Application no: H15-0351-10

Description: Change of use of land to meadow/grazing land/wildlife area

Amendment: Revised block plan

ACKNOWLEDGEMENT OF AMENDMENT

Block Plan - Proposed Change of Use - Machins Farm

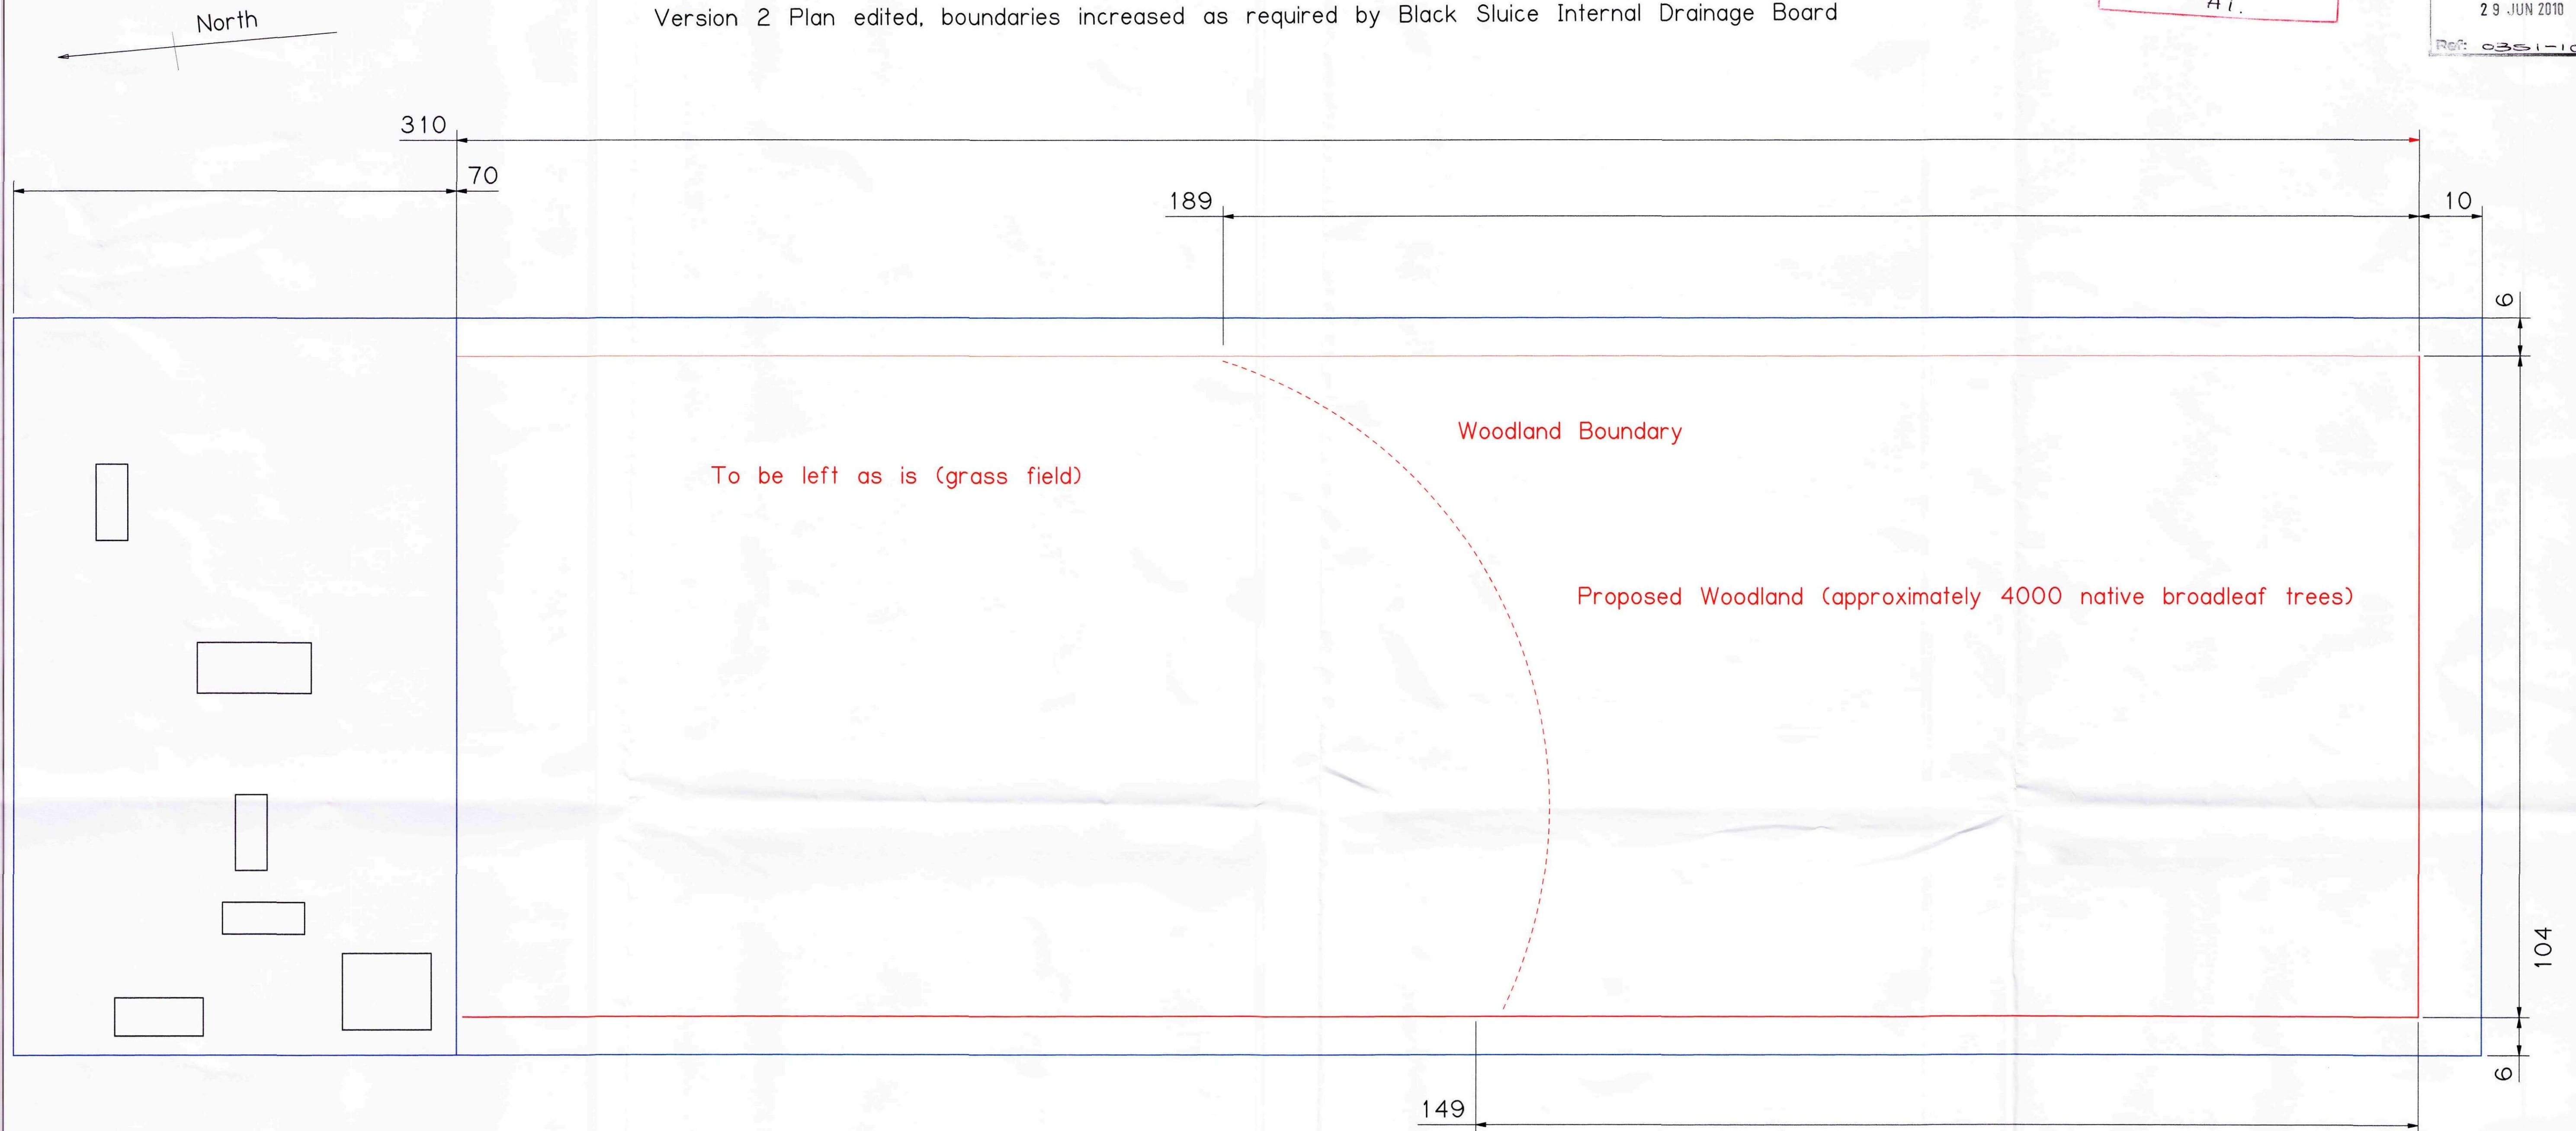
As discussed I have attached a revised block plan.

This plan provides a 10m boundary adjacent to the south drain as required by black sluice internal drainage board and a 6m access boundary to east and west just in case access is required.
